MEMORANDUM

TO: Rick Knowland, Planner
FROM: David Senus, P.E. & Ashley Auger, E.I.T.
DATE: April 21, 2014
RE: IMT Expansion, Level III Site Plan Application

Woodard & Curran has reviewed the Level III Site Plan Application for the proposed International Marine Terminal (IMT) expansion at 460 Commercial Street in Portland, Maine. The project consists of expanding the existing IMT facility and will result in approximately eight acres of new impervious area.

SHEET NUMBER
C08
11 OF 113

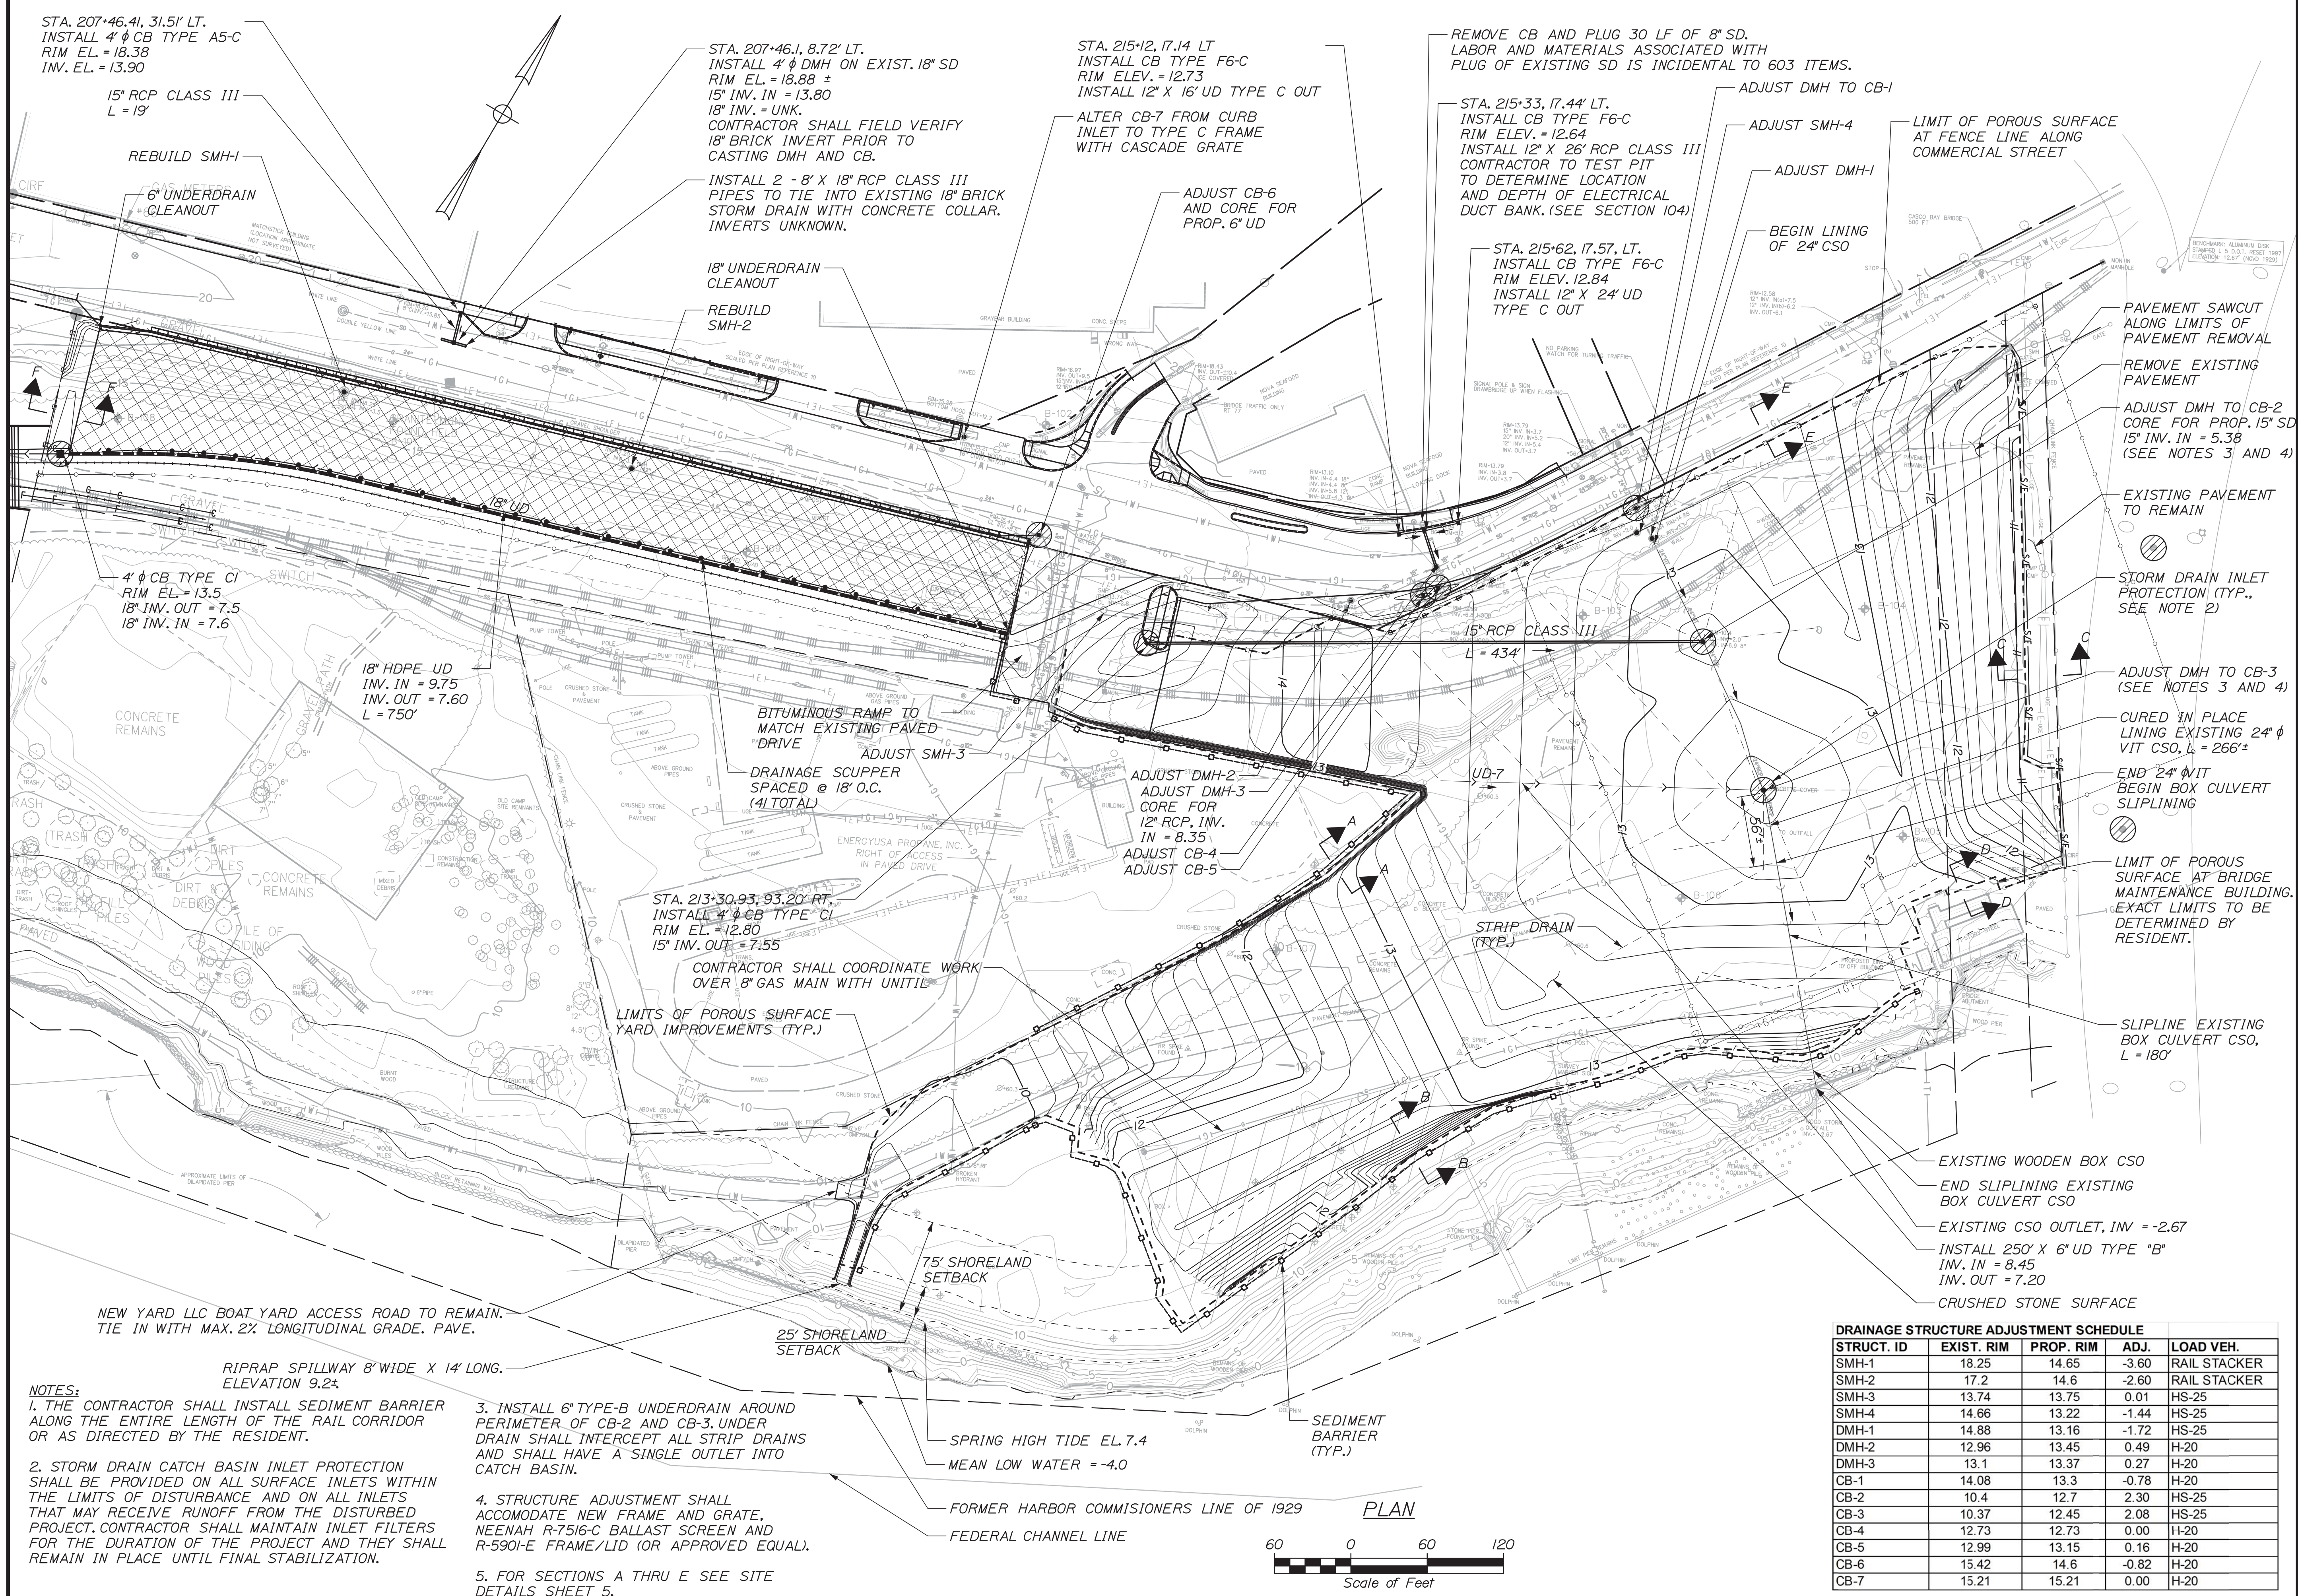
- 8) As part of the PWD Conditions of Water Service, the existing domestic service to the Util site must be brought up to current standards, and the new services installed to serve the New Yard, LLC's boat yard must be terminated. It does not appear that the Site Utility Plan currently reflects these conditions. The Applicant should clarify.

SHEET NUMBER
C09
12 OF 113

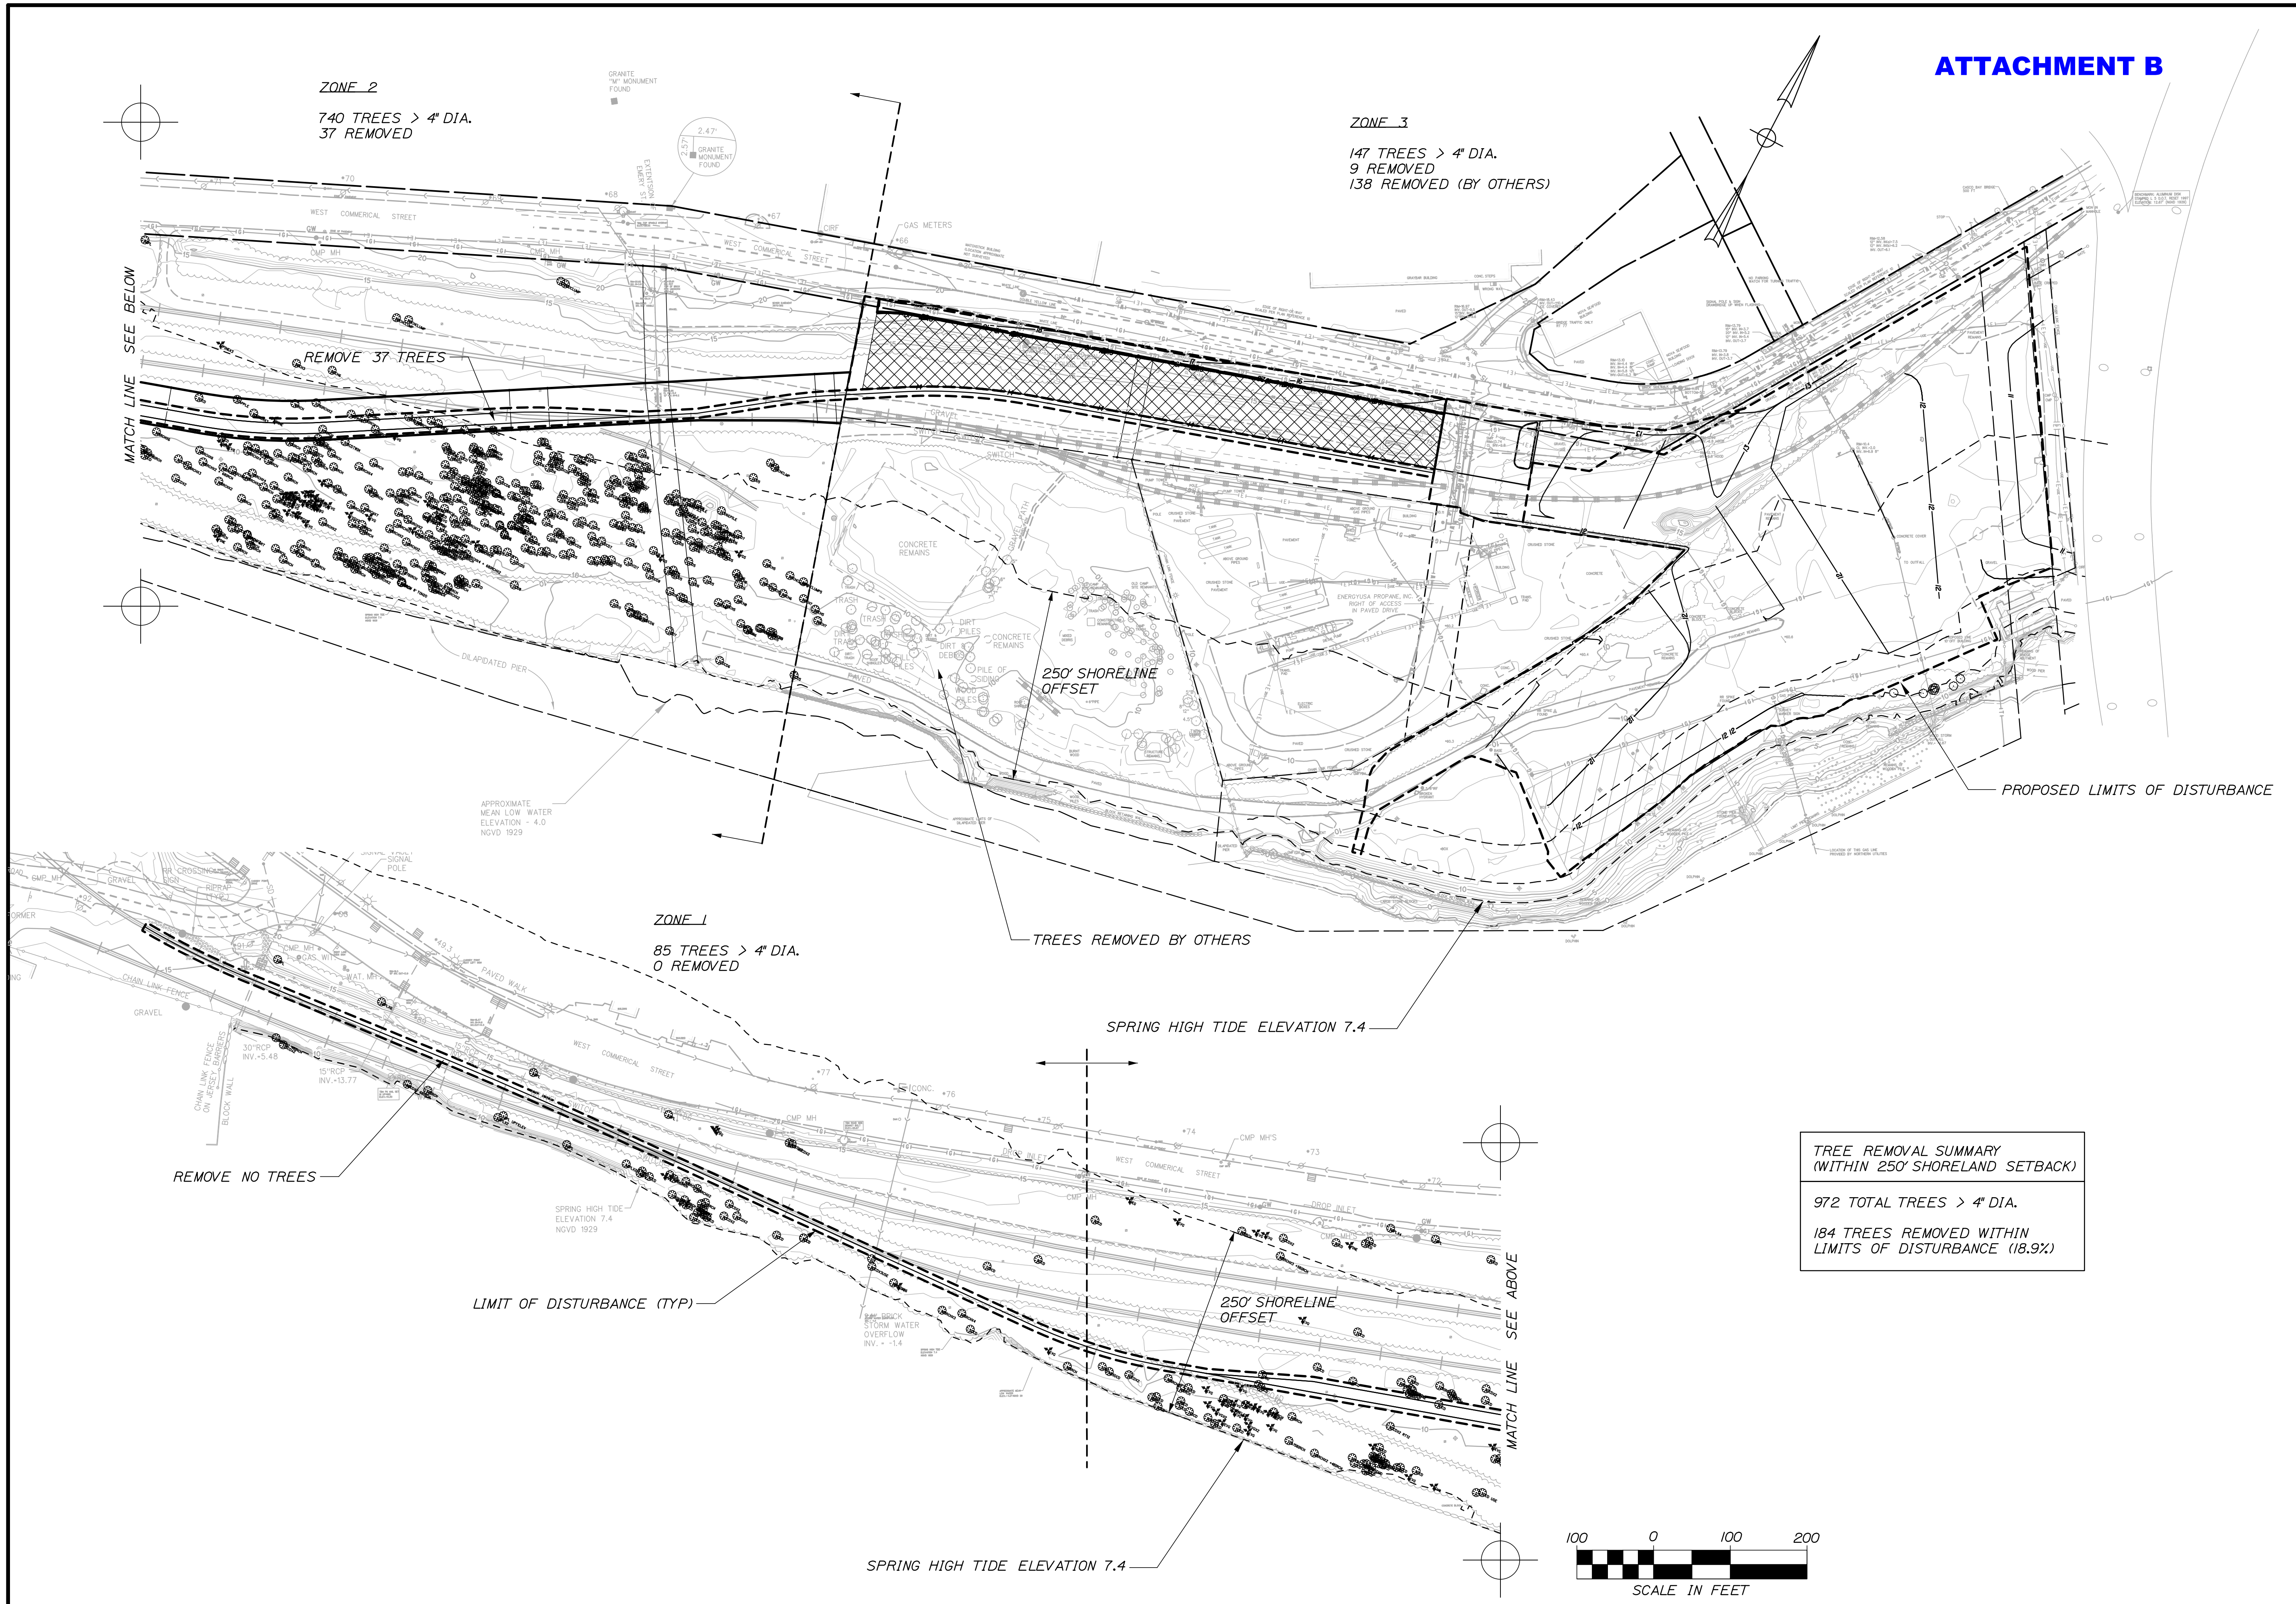
- 10) The proposed grading shown on Sheet SW2 and SW6 in Appendix D of the Stormwater Report and Sheet C8 - Site Grading and Drainage Plan do not appear to match. The Applicant should clarify.

SHEET NUMBER
C13
16 OF 113

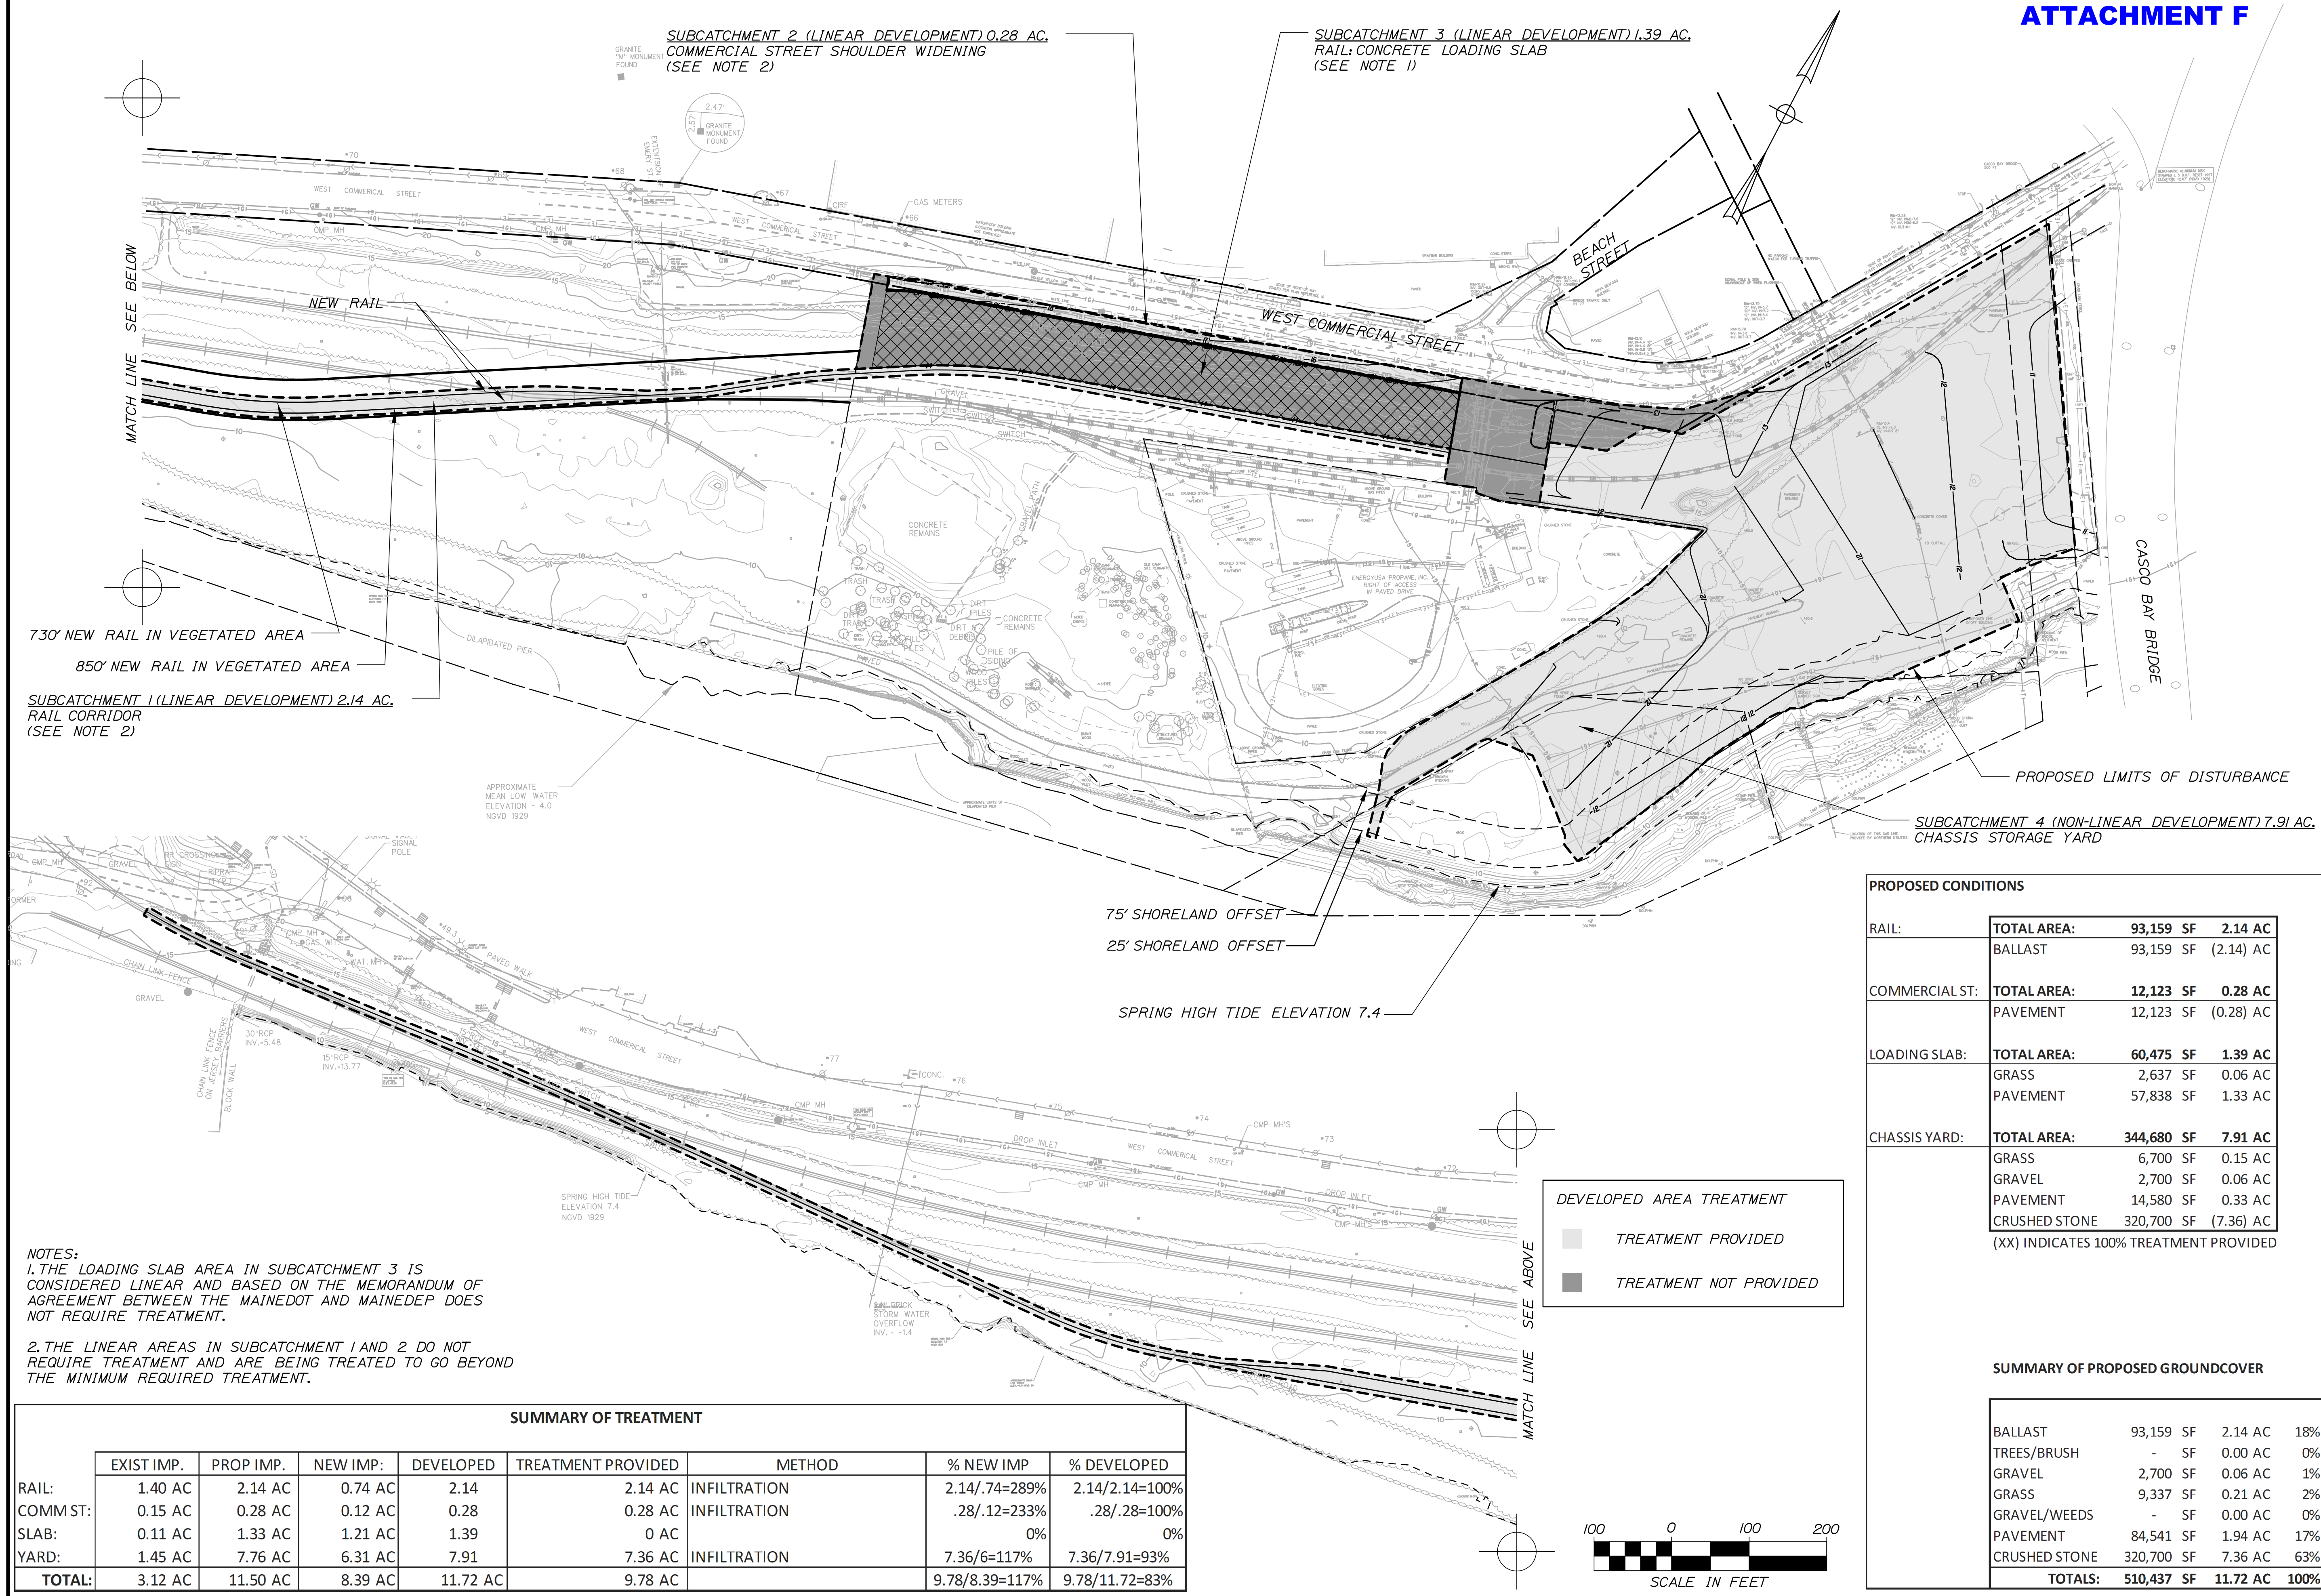
- a) Basic Standard: The Applicant has provided a plan, notes, and details to address erosion and sediment control requirements, inspection and maintenance requirements, and good housekeeping practices in general accordance with Appendix A, B, & C of MaineDEP Chapter 500; refer to sheets SW 7, SW 8 & SW 9. These plans should be made available to the contractor as part of the construction documents. The erosion and sediment control detail sheet (C11) should include details for stone check dams and a sediment barrier.
